From: Simon Davis
Sent: 19 February 2019 11:27
To: 'Charlotte Grant' [REDACTED]
Subject: RE: Wilko Site, London Road, Bognor Regis BR/270/18/PL

I write further to my email from last week. I had a meeting this morning with the Group Head of Planning and our Director of Place in which I presented this application. I am afraid that a few points came out of this that are contrary to some of the opinions given last week. These are set out below:

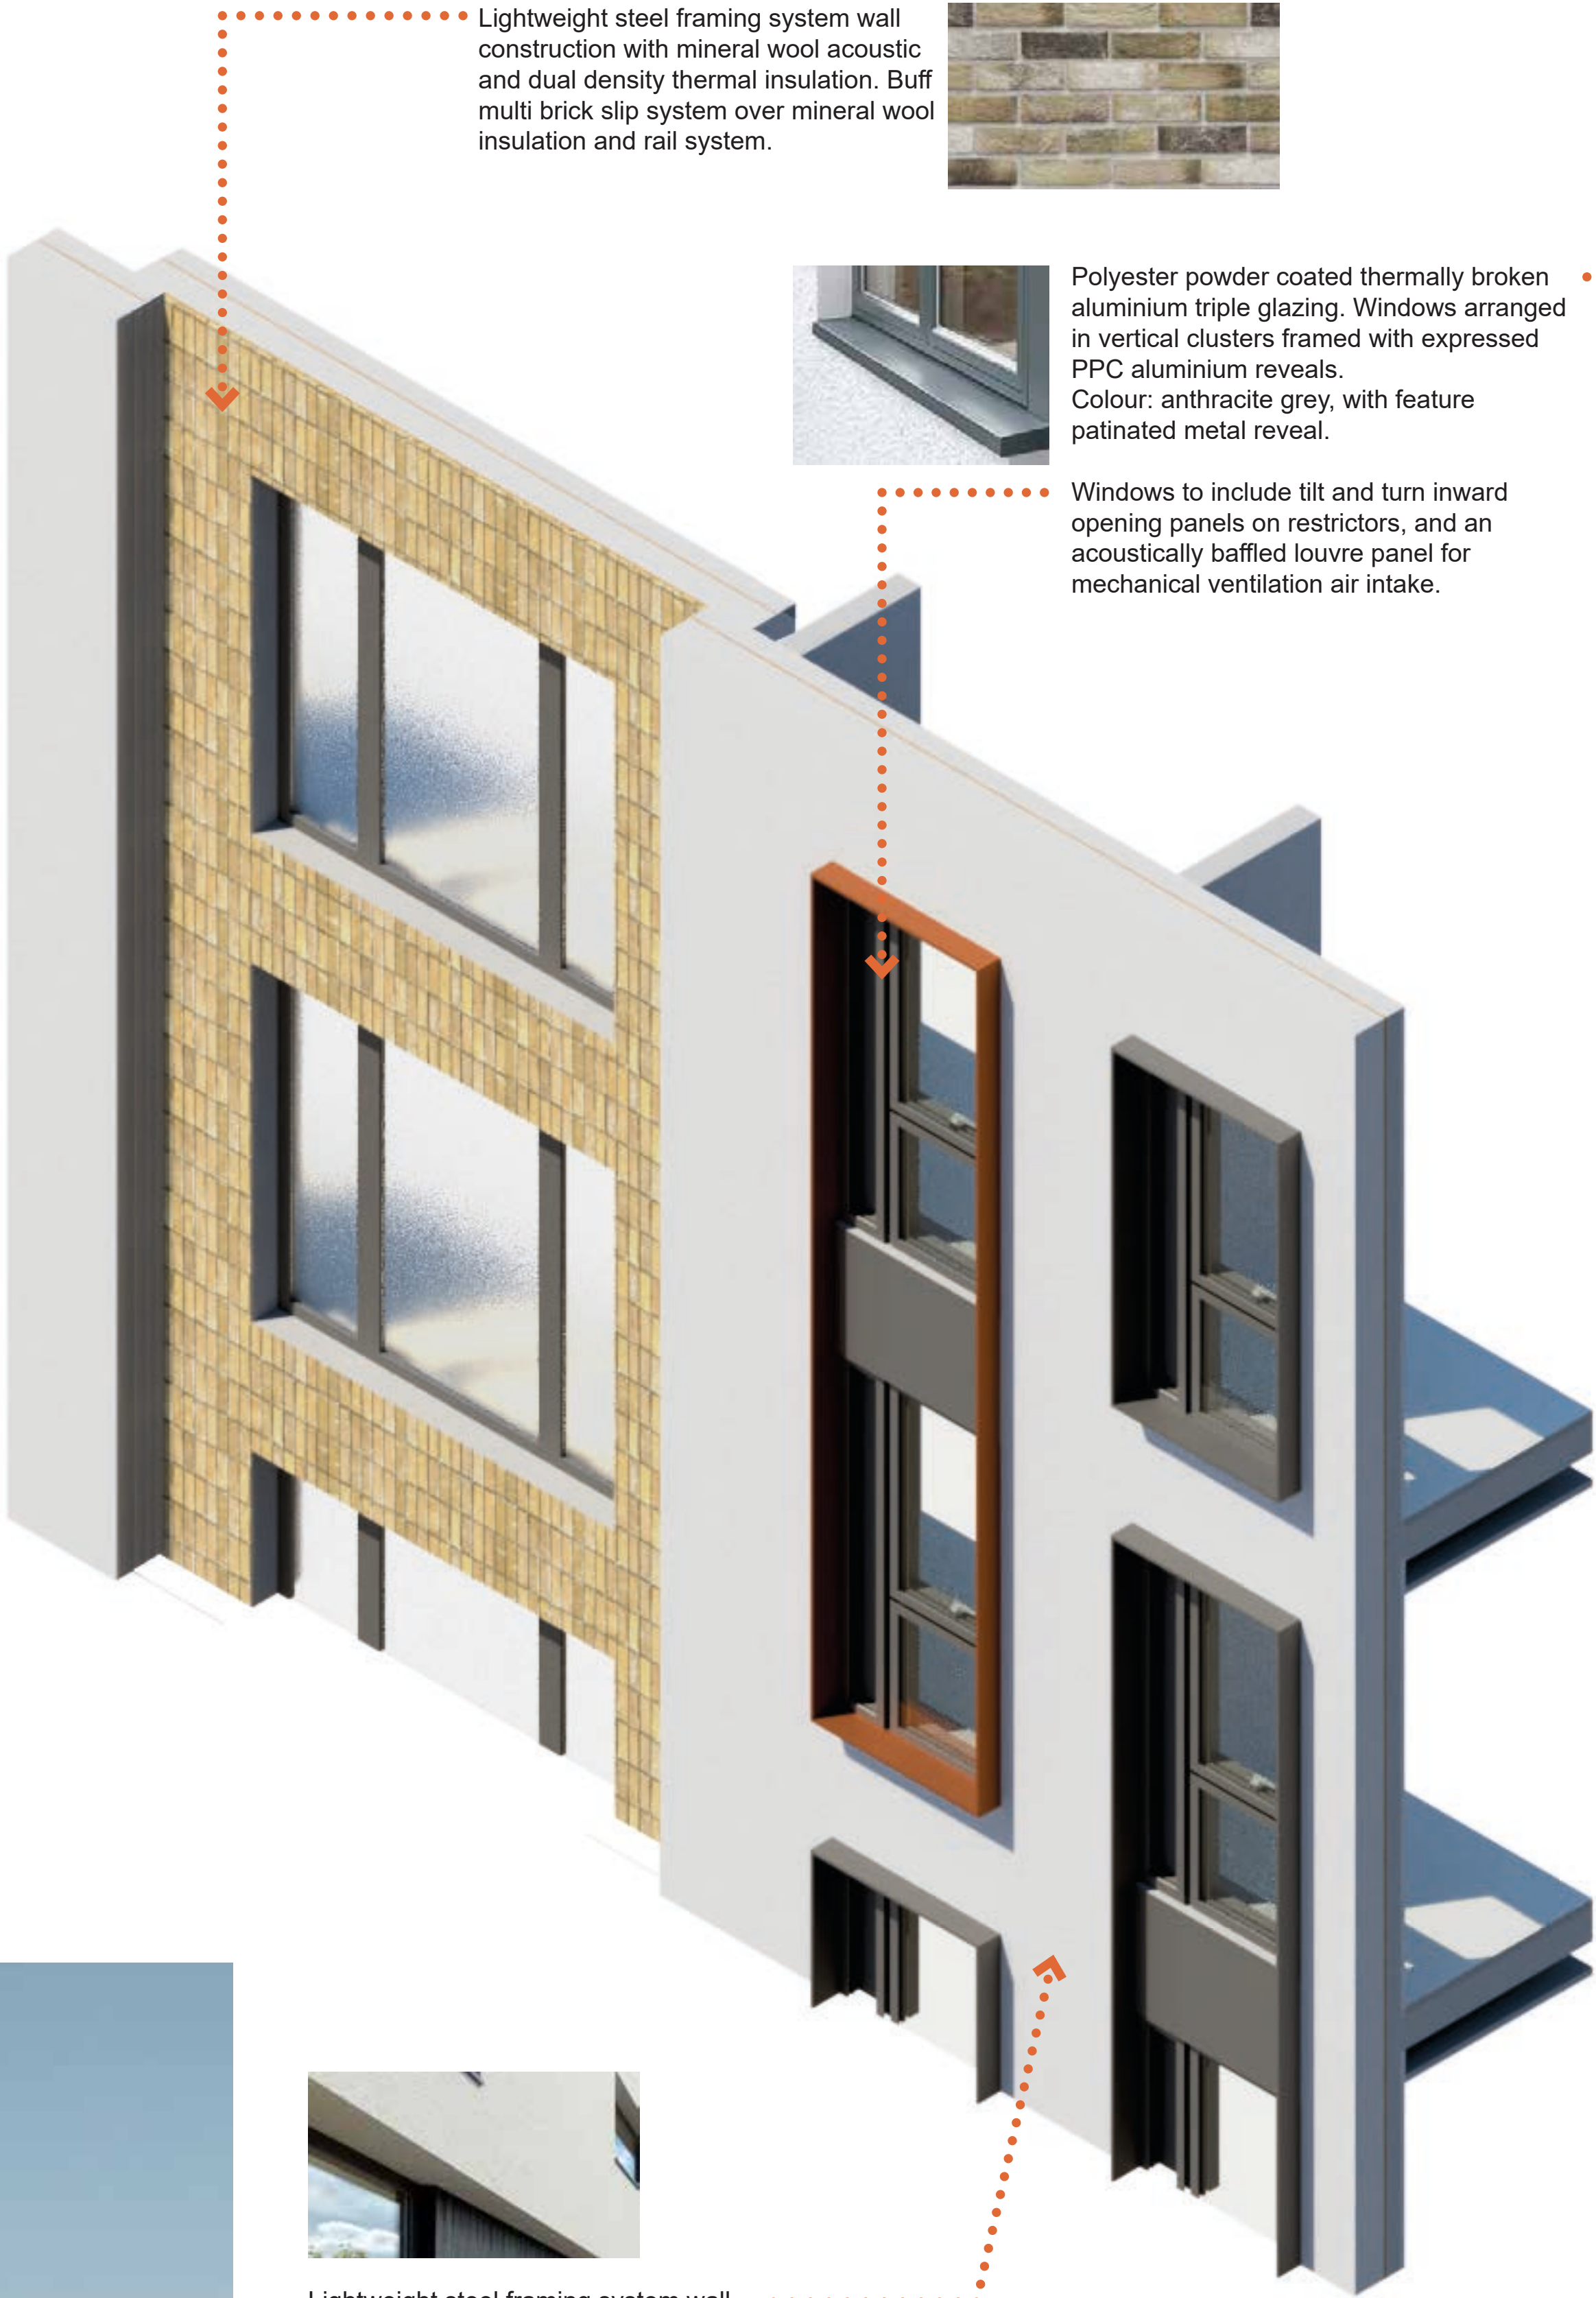
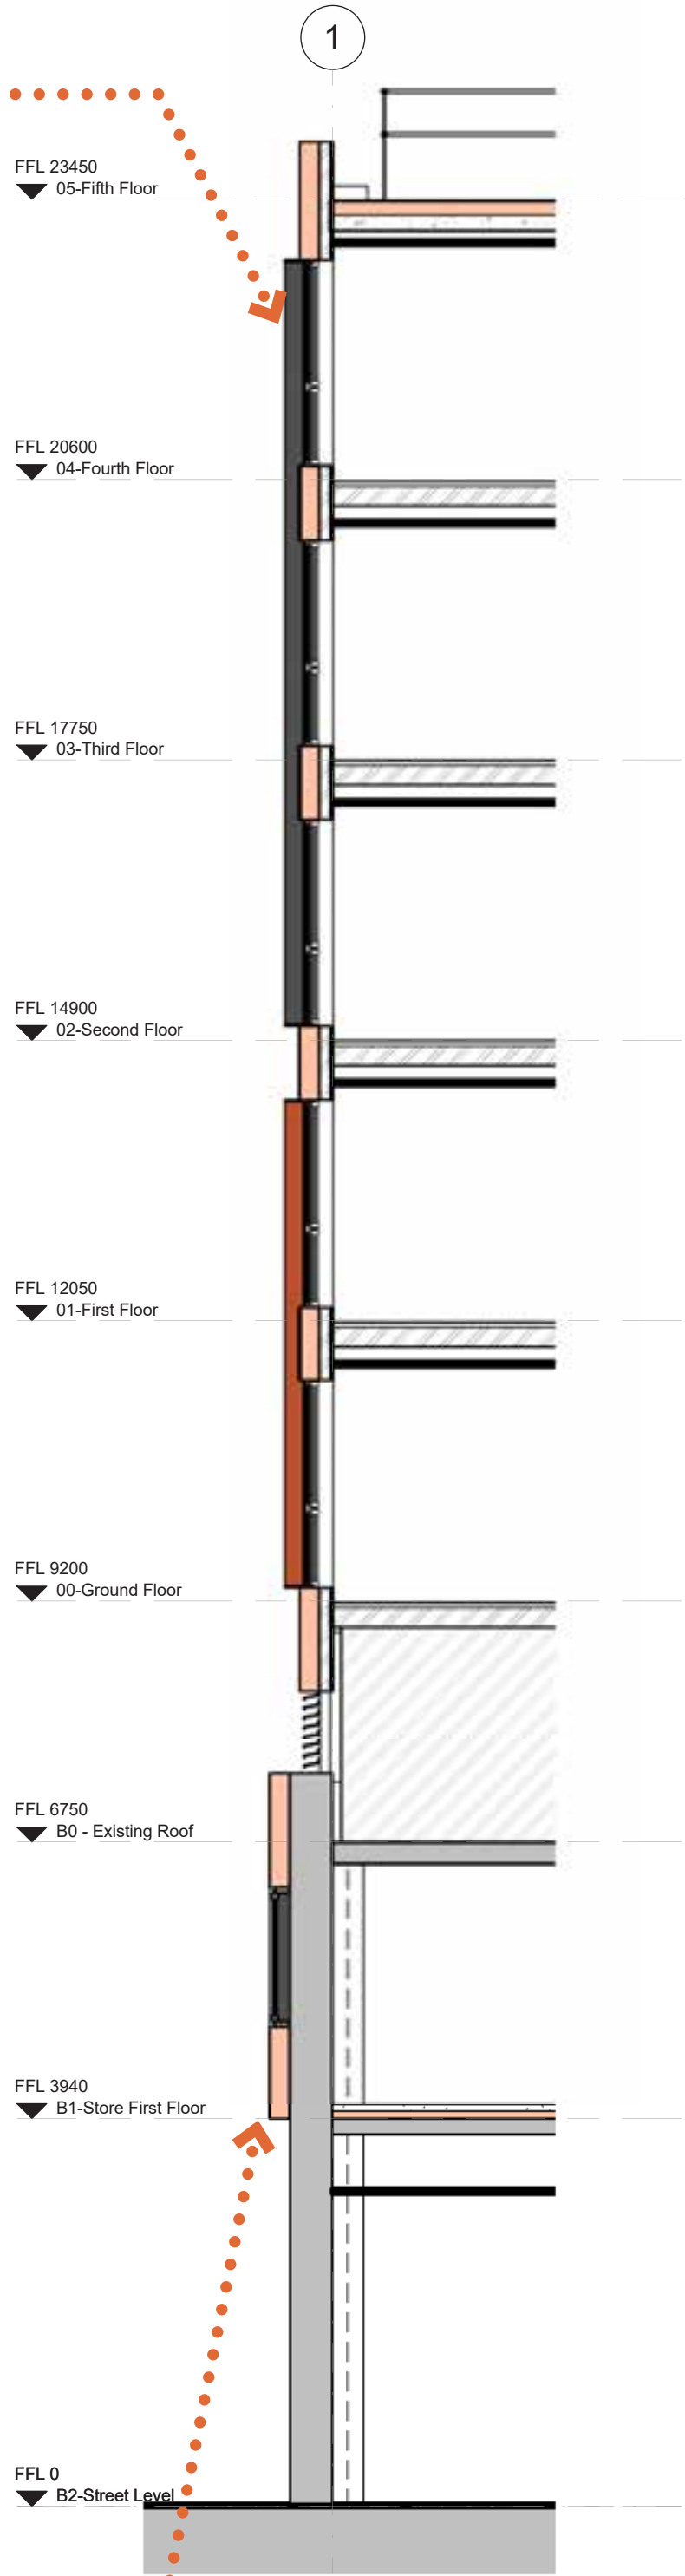
1. It was felt that there is no continuity between the Wilko's Bedford Street elevation and the new building proposals above.
2. It was felt that there is no relief to the starkness of the sheer elevation upwards – options suggested setting the new build away from the Bedford Street edge of the Wilkos building and/or adding in some features within the elevations to add relief – for example some bay style or recessed windows. It was felt that the elevation is very flat compared to Fitzfleet House for example. Note that there were no issues raised with how the London Road elevations are treated.
